**Subject:** R-6 Small Infill Design Review – 107 Monument Street

**Written by:** Caitlin Cameron, Urban Designer

**Date of Review:** Friday, August 7, 2015

1 NORTH ELEVATION
 A2.2 1/4" = 1'-0"

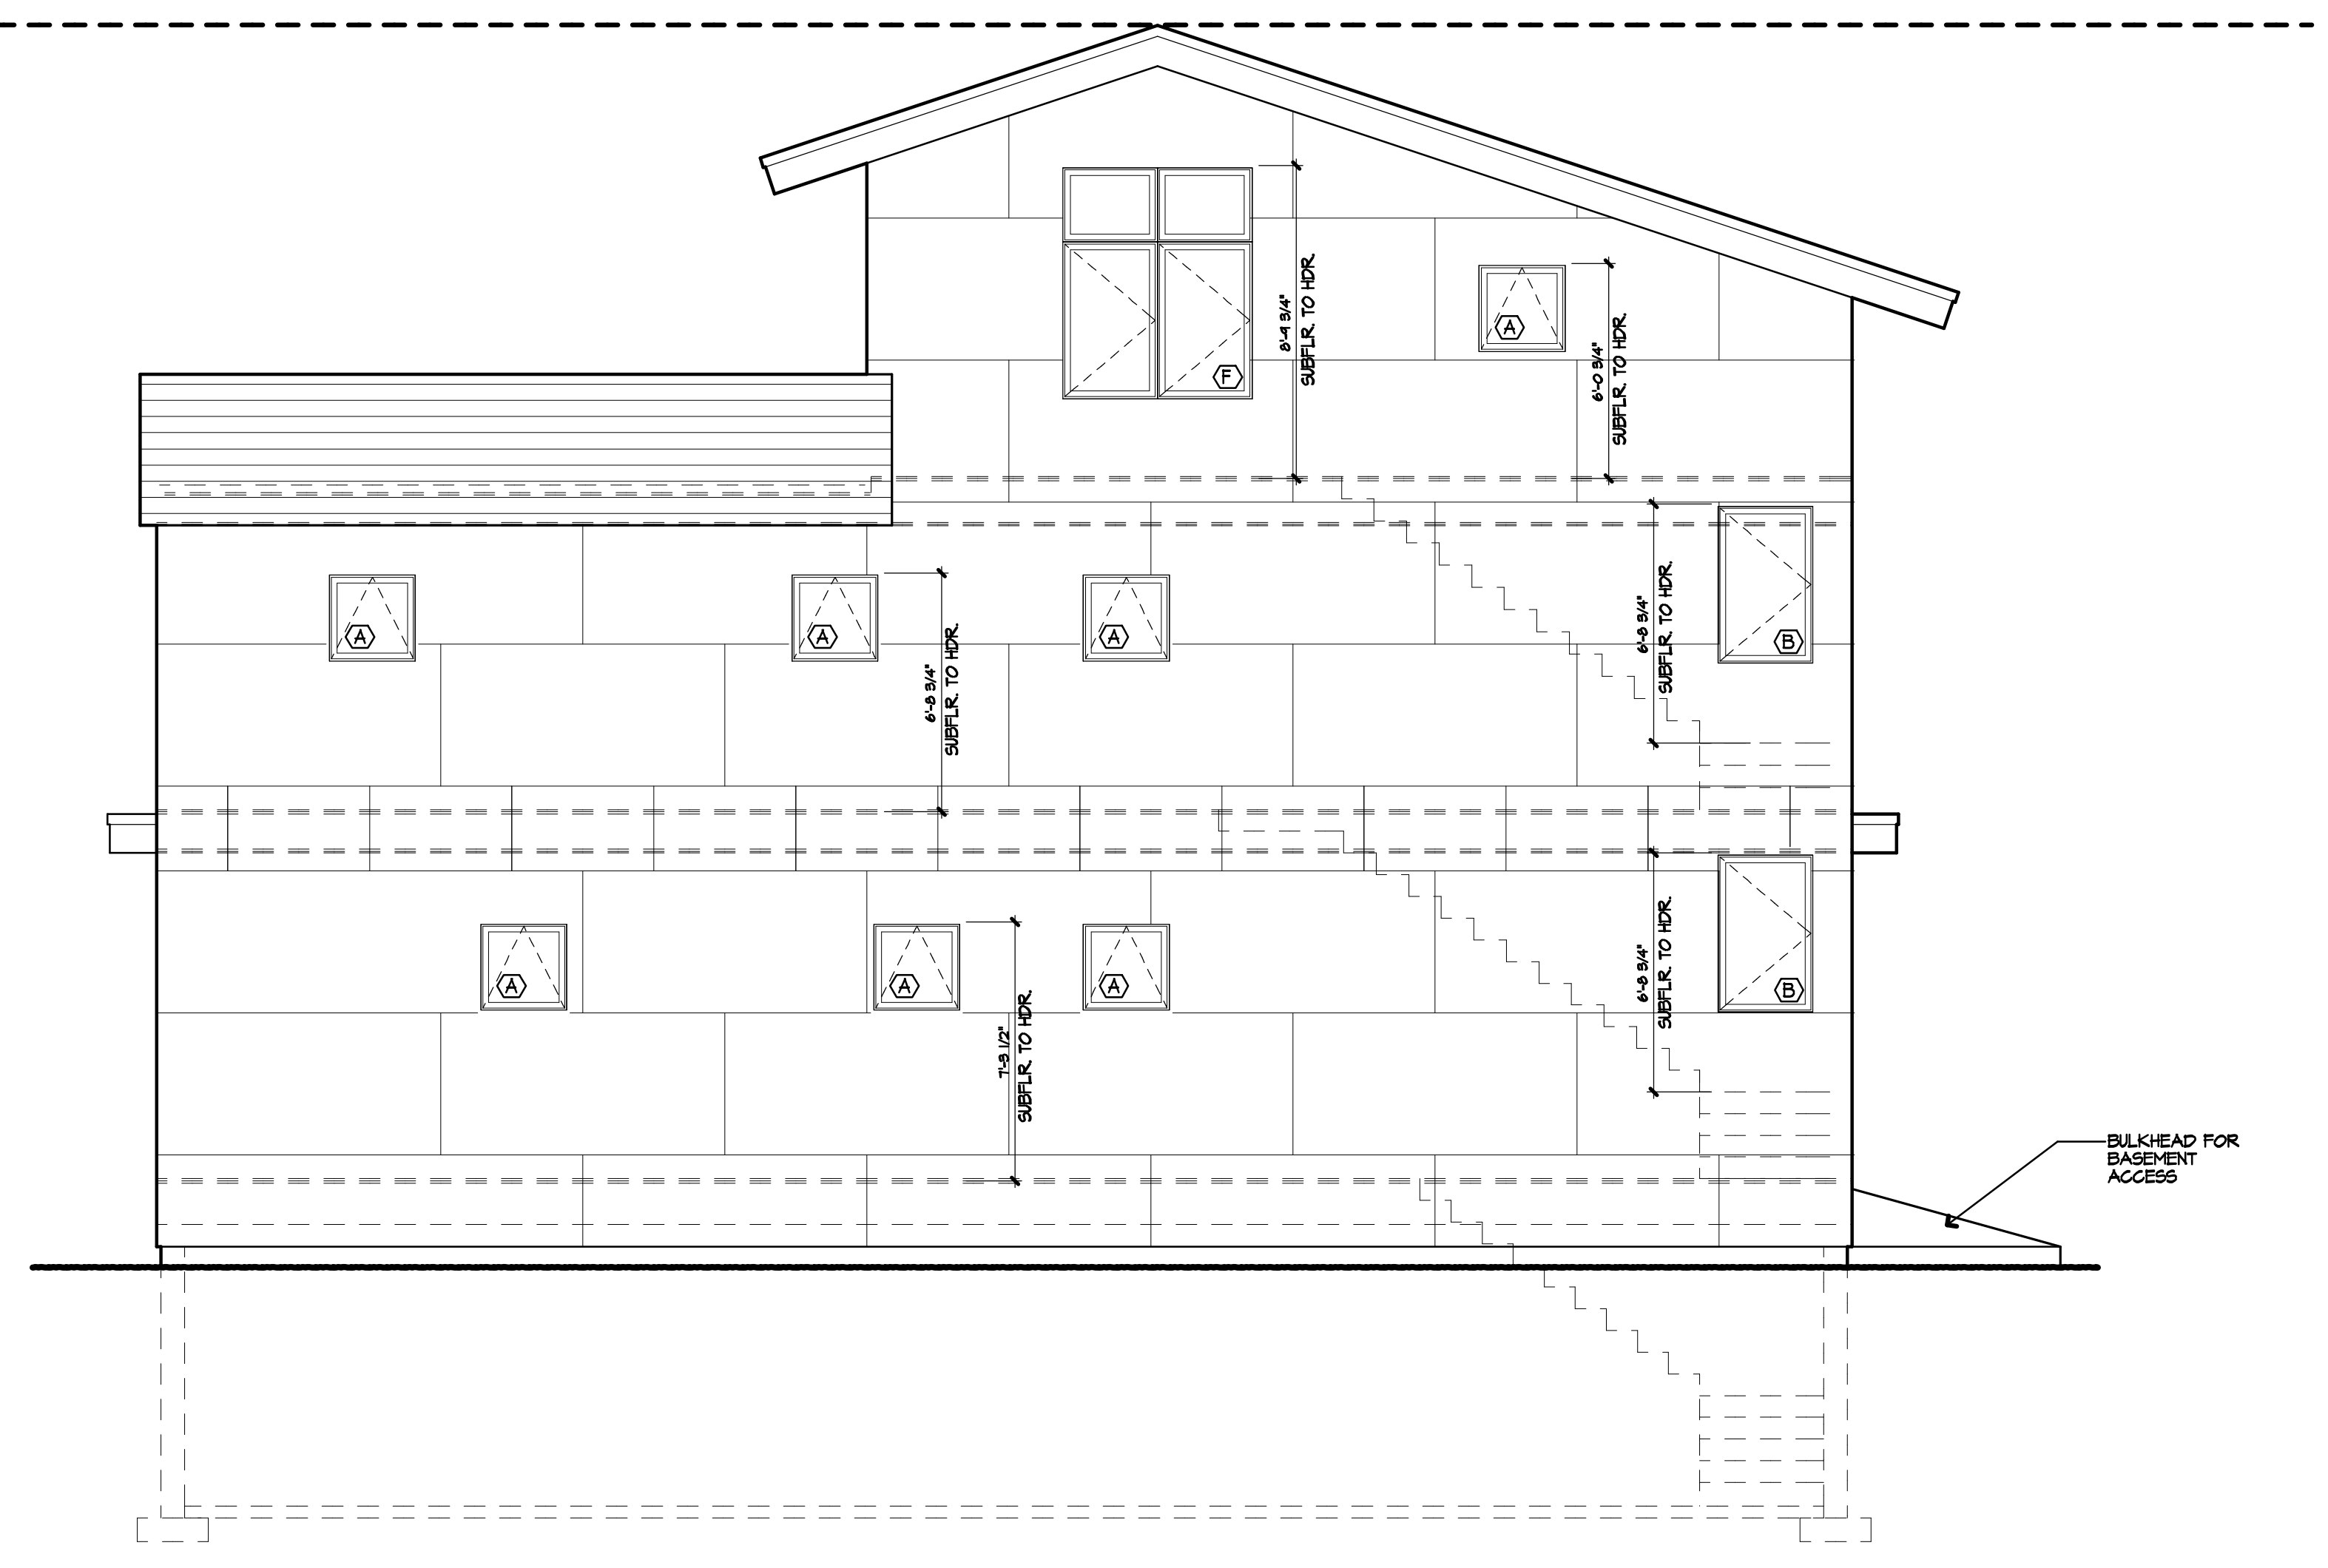
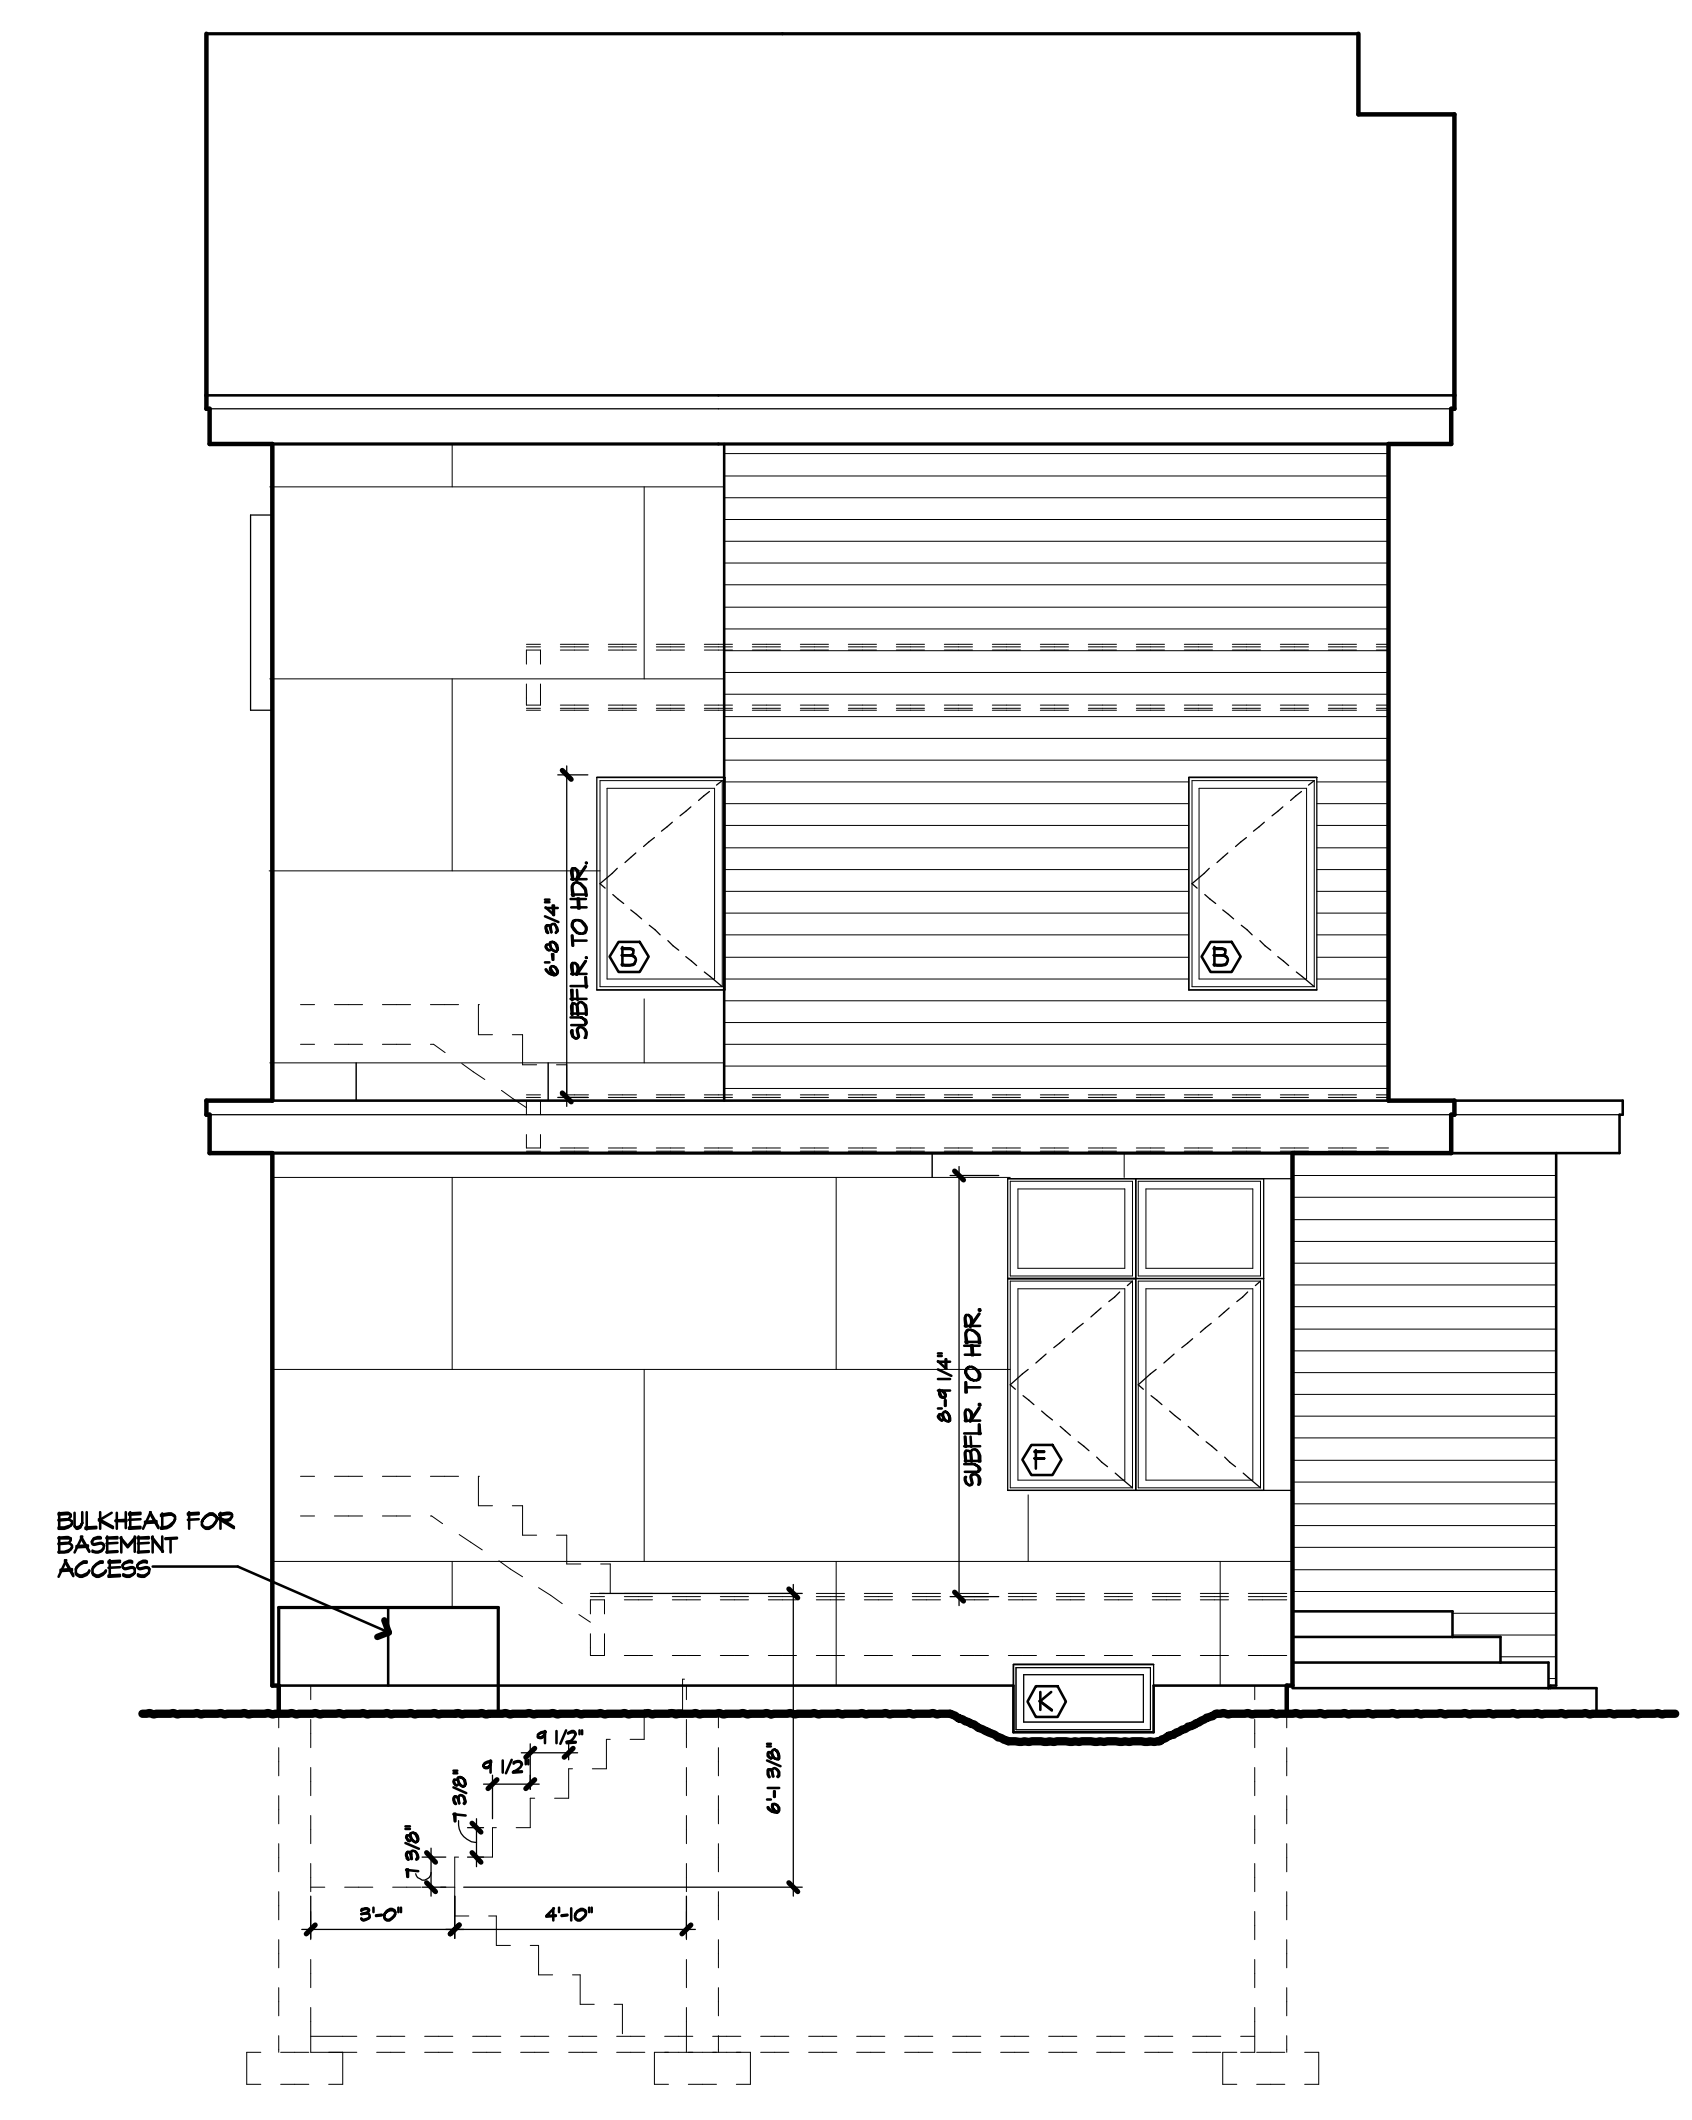
*Principle A Overall Context* – Met – the scale and height of the proposal is consistent and compatible with the surrounding residential context. The form is more contemporary with an asymmetrical roof but building form, proportion, and orientation are similar to the residential context. The two-story front portion of the building sits proud at the street with the taller, contemporary roof line setback, therefore mitigating the visual impact.

- *B-1 Massing:* The proposed mass is harmonious with the massing of the existing buildings in a two block radius.
- *B-2 Roof Forms:* The proposed roof form does not refer to the architectural forms found within a two-block radius which are predominantly front-end gable and flat roofs.
- *B-3 Main Roofs and Subsidiary Roofs:* Met – there is a clear main roof form.
- *B-4 Roof Pitch:* The standard requires that gable roofs shall be symmetrical and have a pitch between 7:12 and 12:12. The roof pitch was not provided but looks to be less than 7:12.
- *B-5 Façade Articulation:* The project employs three (two required) of the required architectural elements: a balcony, a recessed entry, and a covered porch.
- *B-6 Garages:* Not applicable

*Principle G Materials – Met – The material palette was modified to be harmonious with the character defining materials of the neighborhood. The parapet wall at the front of the building uses a material that is consistent with the neighborhood but is designed in a way that is different from the predominant architectural forms. After a conversation with the architect, staff determined, though not ideal, this parapet configuration was acceptable given the desires of the homeowner for privacy.*
